Consultation Response from KC Lead Local Flood Authority		
2018/92842 Former Combs Hostel, Hall Lane, Thornhill, Dewsbury, WF12 0PL		
Reserved matters application for erection of 34 dwellings pursuant to outline permission 2014/92815 for demolition of existing hostel buildings (C1) and erection of residential development		
Date Responded: 18th July 2021	Responding Officer: Paul Farndale	Responding Ref:

PROPOSED LAYOUT

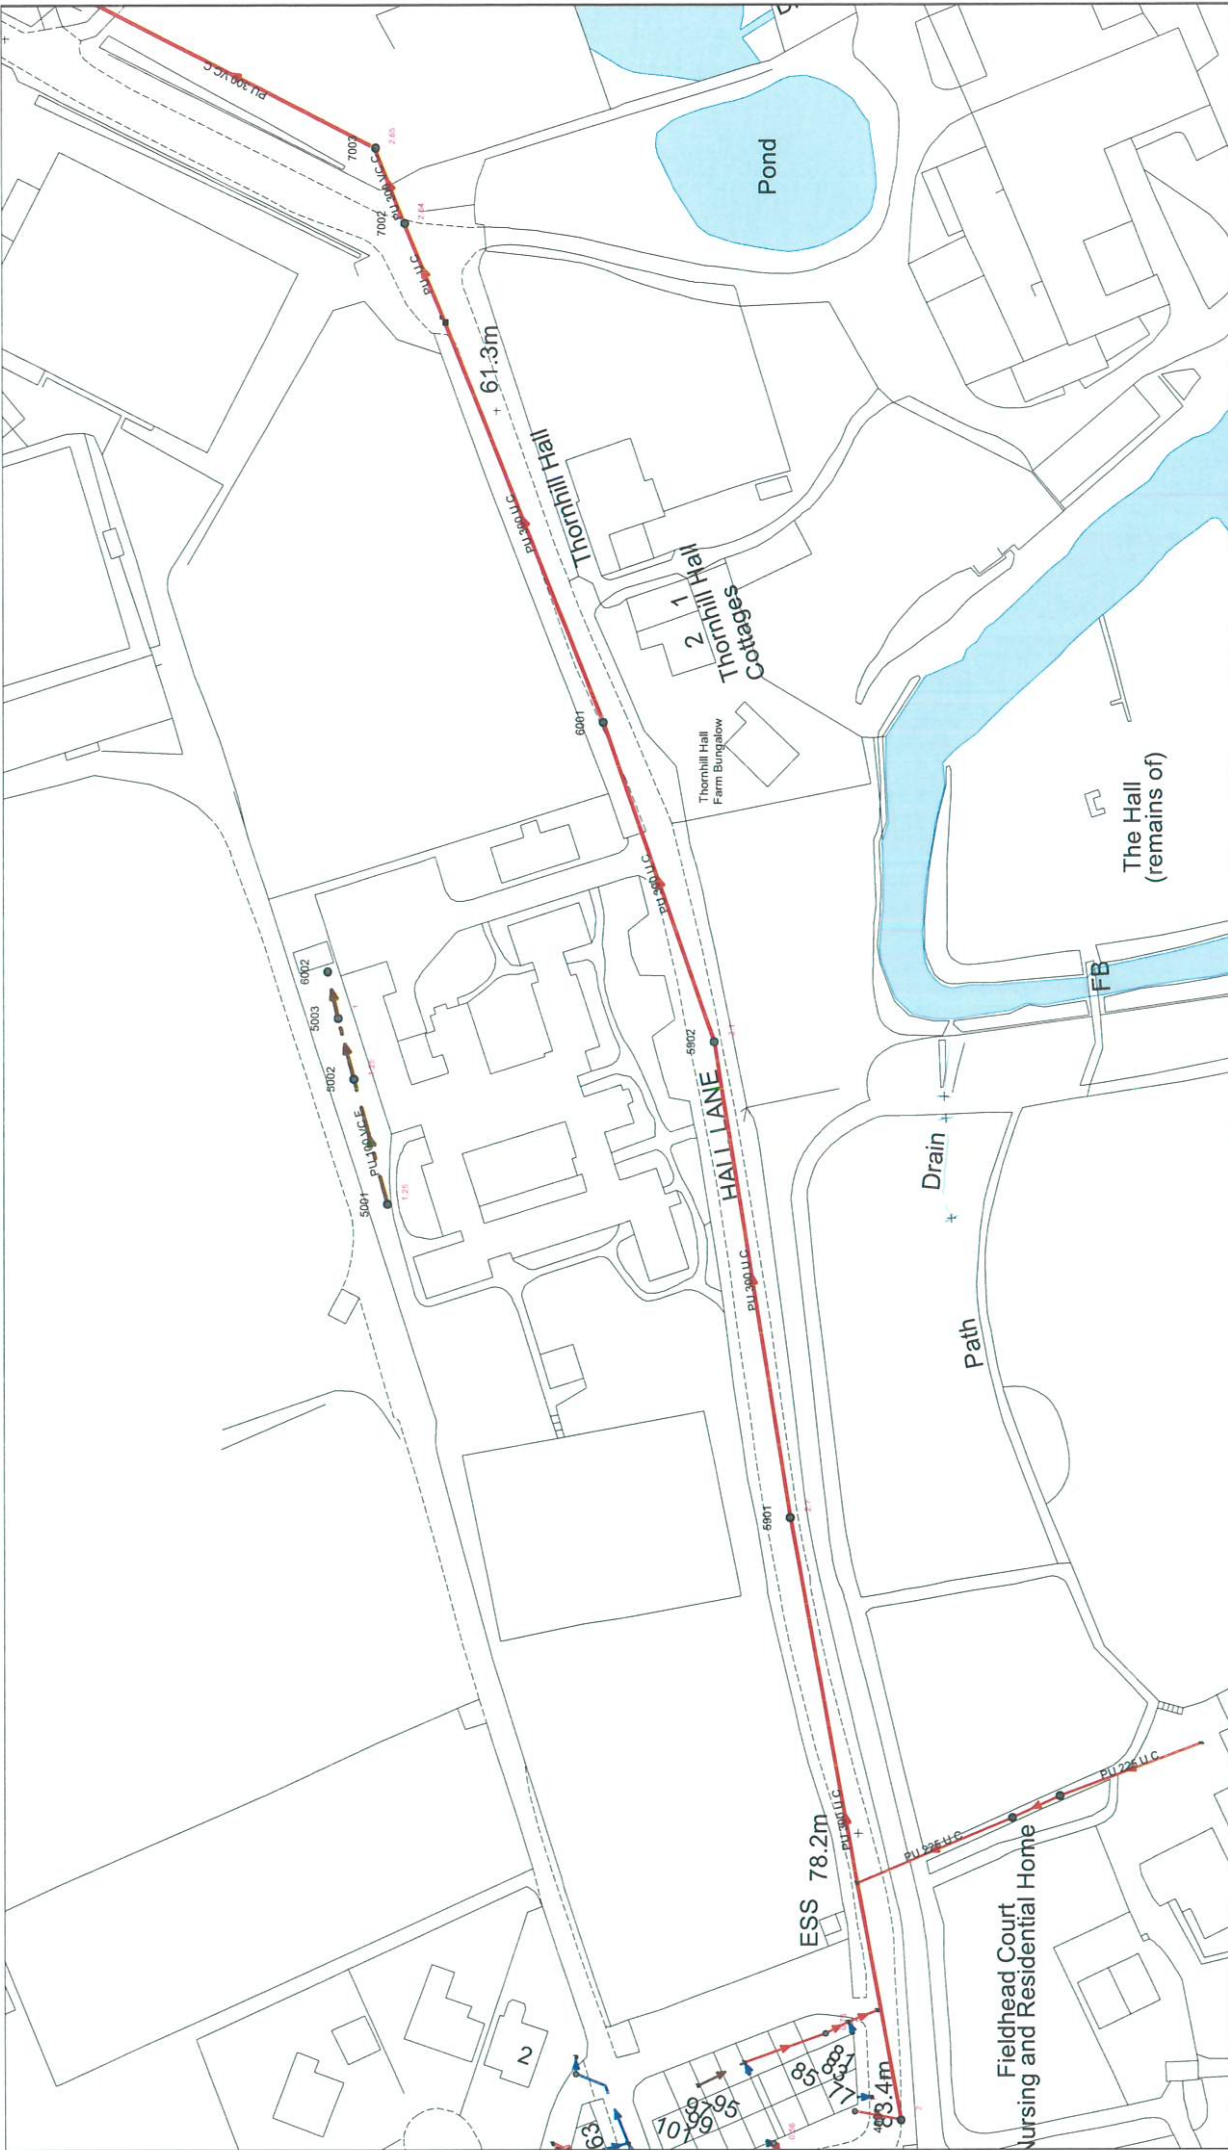
The LLFA continues to OBJECT to this application due to a lack of information in comparison to most applications, to clear demonstrate on whether the layout can accommodate space for water without flooding.

Overland storage in the road is not advised on a housing estate due to limited kerb height, the creation of a basin and the potential effect of bow wave action flooding properties. It is likely that the full attenuation will be required underground.

Flood routing has not been addressed at all and a layout is being applied for. The layout should be designed around flood routing and not the other way round.

An indicative system based on the identified hard standing and a 3.5l/s discharge rate will be required to show that there is space made for attenuation, and all properties can connect by gravity and in term the invert level of an attenuations system can connect by gravity to the assessed level of the outfall.
